**SUBMISSION  
TO AN BORD PLEANALA  
ORAL HEARING  
NEWCASTLEWEST**

**CASE N. NA04.310286**

## **Bats – XC212 Crossing Ballycoskery**

# PLAN 4A (ii) XC212 - BALLYCOSKERY

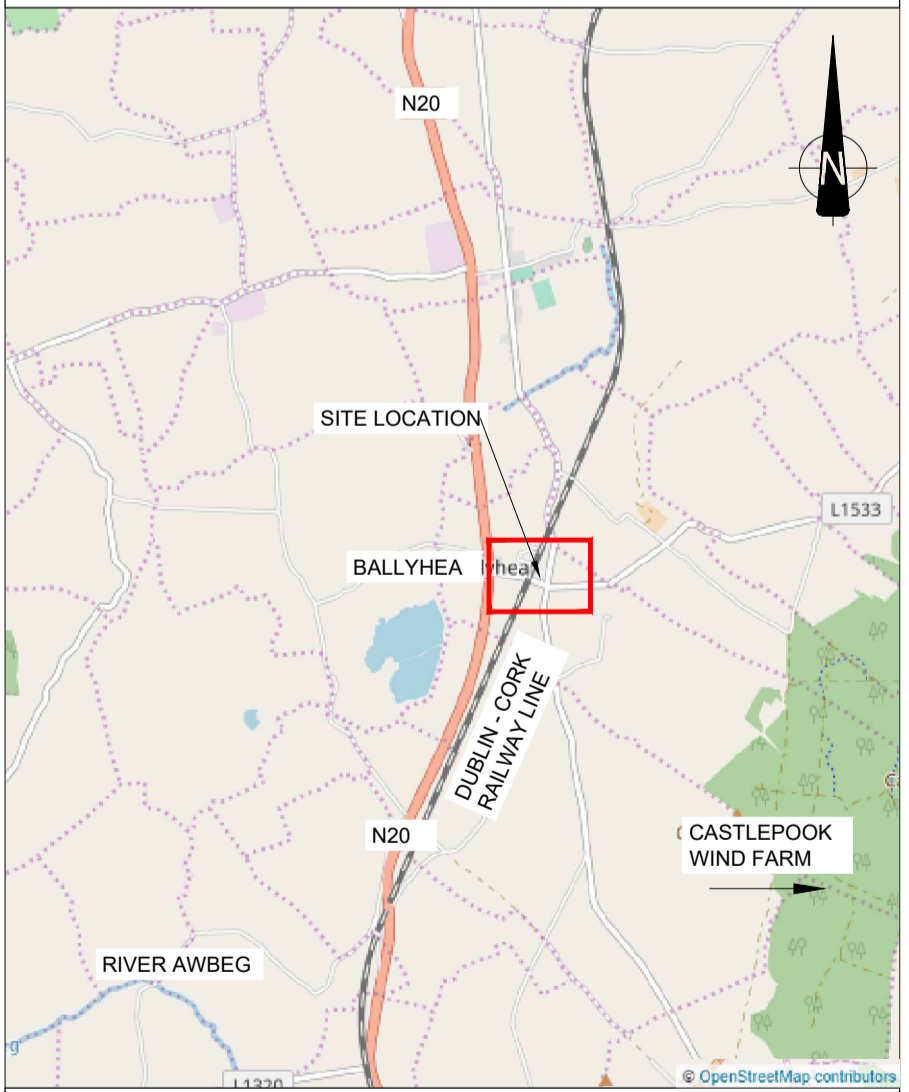
The Parochial House is located c. 32m from the red-line boundary and is therefore well within the stated study area. At the rear of the property (Plate 1) there is a well-established access and egress point for bats. The staining and droppings are very obvious and no access to the building is required to confirm the presence of a significant roost site. Bat activity has been noted consistently at this structure, particularly in the summer months, for many years.

The bat surveys carried out as part of the EIAR assessment failed to identify the location of a long-established and significant roost. In failing to record an obvious and actual roost, there is reasonable concern that the surveyors may also have failed to adequately catalogue and assess other PRFs within the study area. The potential impact on bats arising from the removal of trees and hedgerows has not been adequately considered. The mitigation proffered is some landscaping that does not appear in any way to have been designed to offset the loss of treeline/hedgerow that may contain PRFs, but most certainly have a function in maintaining habitat connectivity for foraging and commuting bats.

There is no serious consideration of the impact of the construction and operation of the new crossing layout, and the associated light and disturbance impacts on bats that occur within the study area. Overall, the bat surveys as described were inadequate and poorly scoped to properly consider all of the PRFs within 100m of the application boundary. The surveys did not record any signs of a roost site and also did not record the presence of *Myotis* sp. (most likely Daubenton's Bat, *Myotis daubentonii* and Whiskered Bat, *Myotis mystacinus*) that were also recorded during a short-term and single deployment of a passive detector at Ballyhea Parochial House in June 2021.
